**Benjamin Wallace - Re: FW: 2211 Congress St - Unum HO1 - permit 2013-00458**

**From:** Benjamin Wallace [<mailto:wallaceb@portlandmaine.gov>]  
**Sent:** Thursday, April 25, 2013 11:01 AM  
**To:** Brian Curley  
**Cc:** Jeanie Bourke  
**Subject:** 2211 Congress St - Unum HO1 - permit 2013-00458

E7
1/4" = 1'-0"
ELECTRICAL LIGHTING PART PLAN - SECOND FLOOR

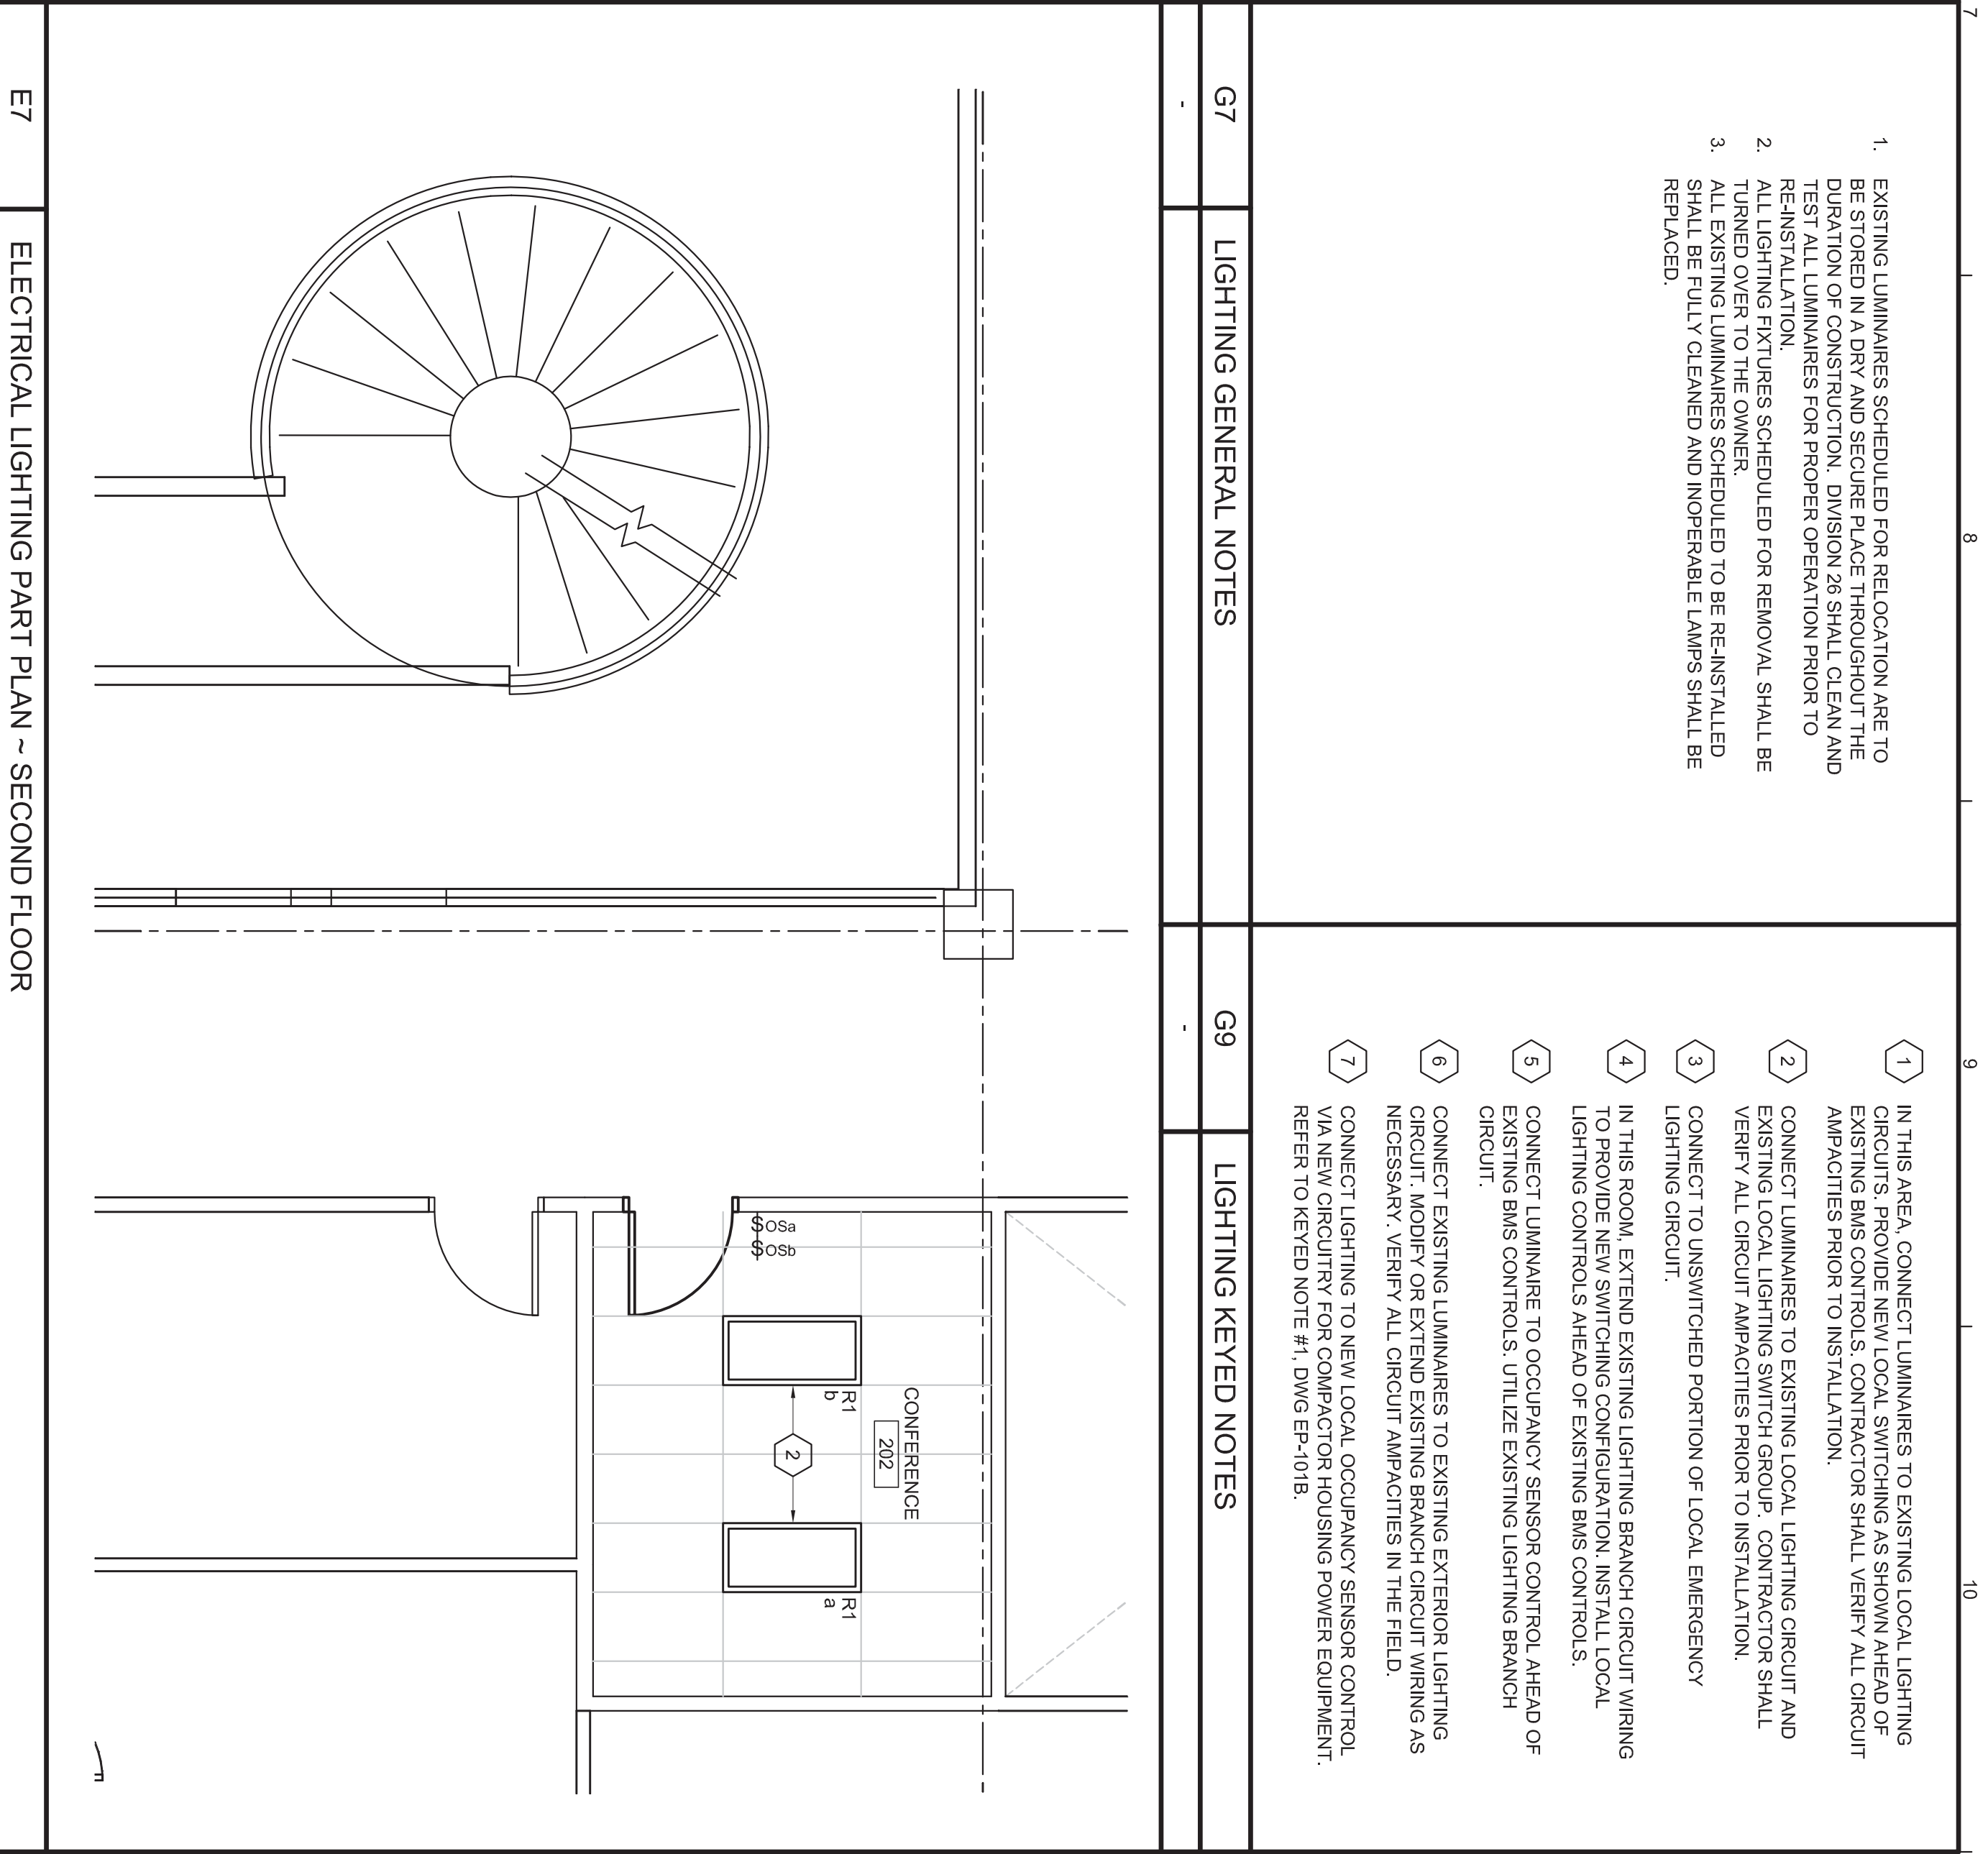
- Many sheets show exit sign arrangements that don't match the egress plan on sheet A-001. In particular the reflected ceiling and electrical plans indicate exit signs directing occupants to Stairs D and E.

ITEM 5 - This will be updated. **Please provide updated reflected ceiling and electrical sheets.**
